FW: Planning Consultation on: WA/39/26/DOC

Application No: **WA/39/26/DOC**

Description of Works: Approval of details reserved by condition imposed under WA/44/25/PL relating to conditions 3-surface water drainage and 4-discharge of flows to watercourses.

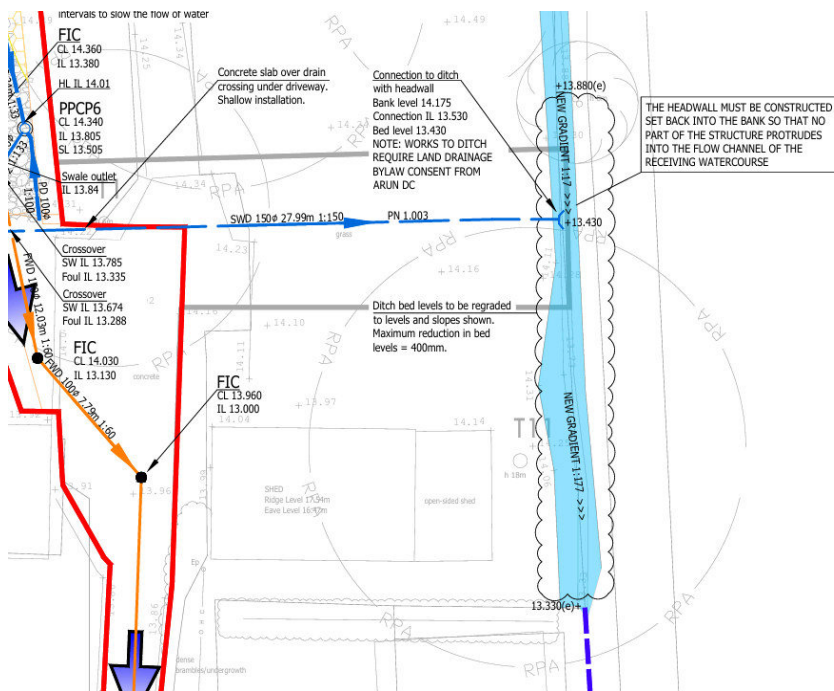
Since this is a general comment from the Engineers, I would suggest you Arboriculturist reviews the drainage strategy proposed and comments on all trees that may be affected. However, the below is a snippet from your current drainage strategy. I think those directly impacted by levelling/excavation works within the ditch are the most crucial.

As for the Arboricultural Information, the report previously provided doesn't cover the full extent of the drainage works required. It is my understanding that T1 (U) shown in the report you attached is to be removed per the latest approved 'Site Plan 2E', so these should not conflict. On this basis, the only tree of concern appears to be the one adjacent the ditch excavation works now proposed. The excavation of the ditch was not known during the original application, so my understanding is that is what they are referring to, and we would need an updated Arboricultural Statement covering this. It may be worth just having your Arborist pass comment on the drainage strategy as a whole and any impacts on any of the on-site trees to be retained if there are others, but the remainder appear to be either avoided or barely impacted.
